Lanktree Land Surveying, Inc.
25510 74th Avenue South
Kent, WA 98032
(253) 653-6423
www.lanktreelandsurveying.com

RE: KCCDS Project No. BL-20-00019

1st Review Response (Letter Dated August 26, 2020 – Rachael Stevie)

SHT
1
OF
2

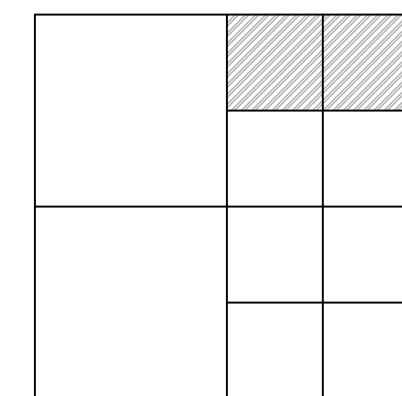
2. Remove the grey shading in the section index If desired, any grey scaling could be replaced with hatching.

Response: Gray shading was changed to hatch.

SHT
2
 OF
2

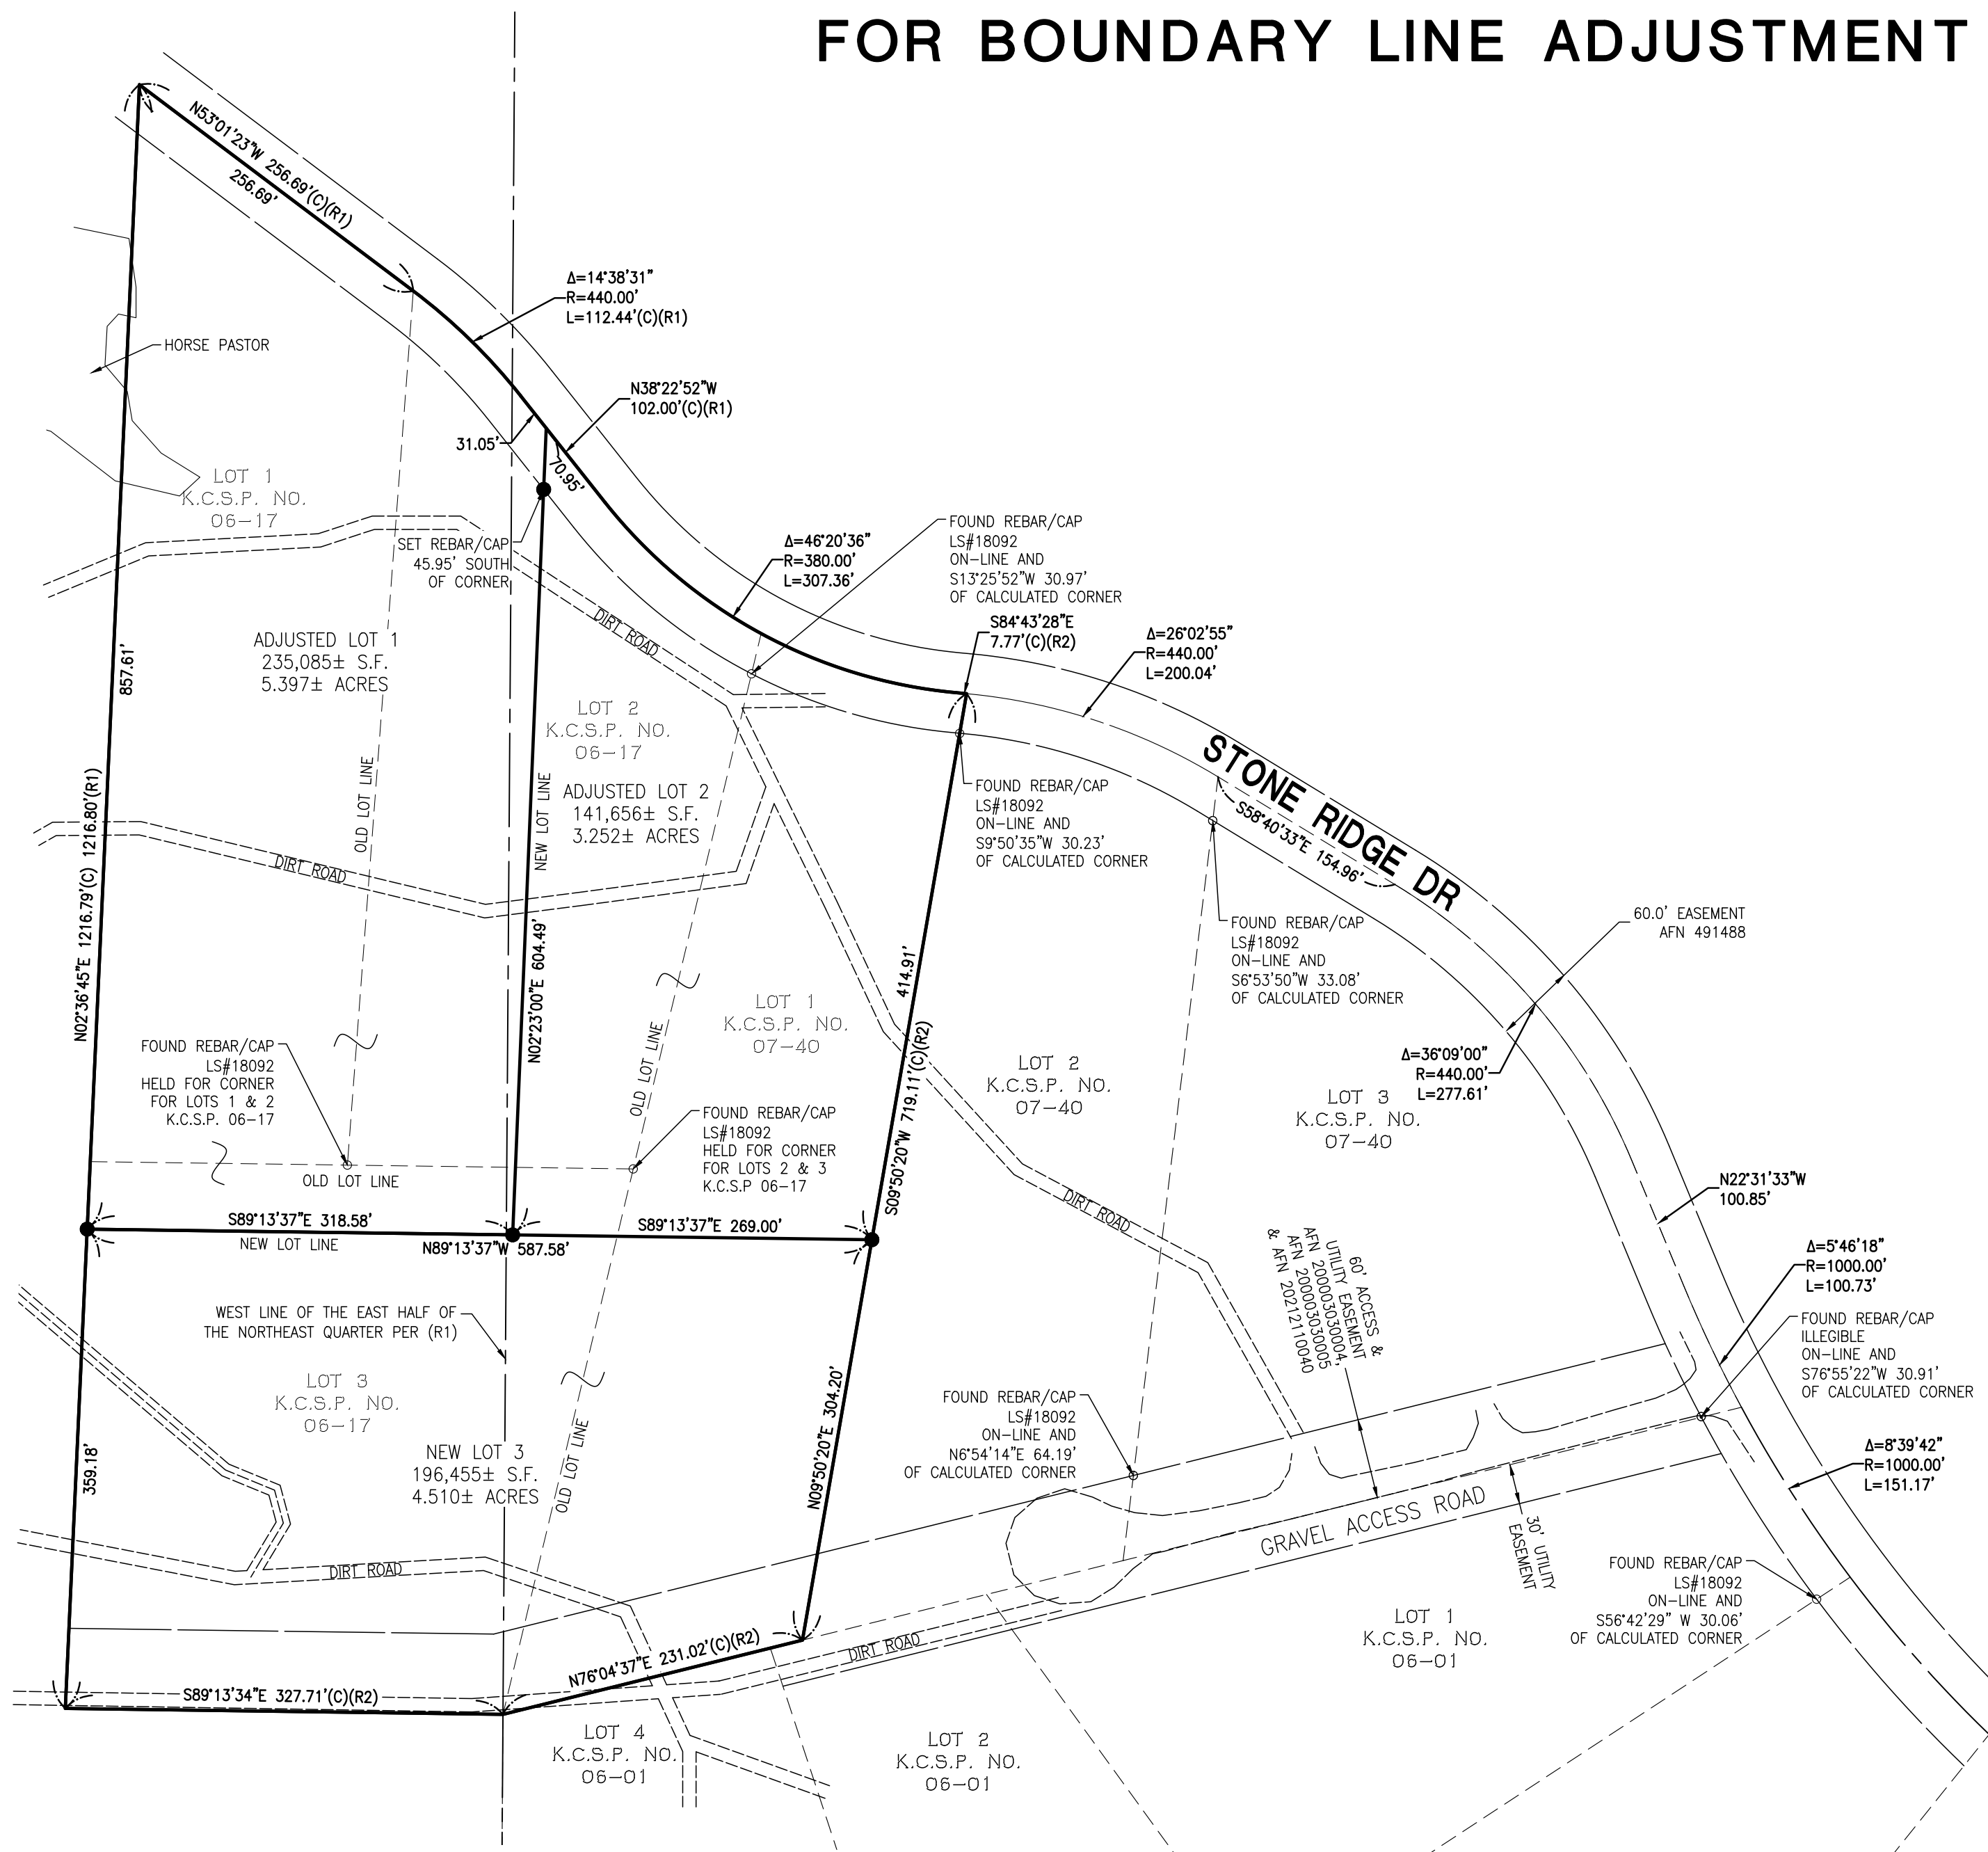
5. There is a North South line that is not described or dimensioned to that falls near the East boundary of Lot 1. Please describe or remove.

6. Please include the offset distance to the corner set as a witness to the NE corner of Lot 1.

9. There appears to be a sizable portion of Lot 1 being utilized by the neighbor to the East. Please note and show this usage line.

Response: Called out the line as being the West line of the East Half of the Northeast quarter.

Response: Added call out of "set rebar & cap 45.95' South of corner" for the Northeast corner of Lot 1.

Response: Dirt roads have been added to the sheet 2. The horse pasture to the West does not encroach as far to the East as shown on Google Earth. Please see attached PDF of sheet 2 with an aerial attached to show the horse pasture.
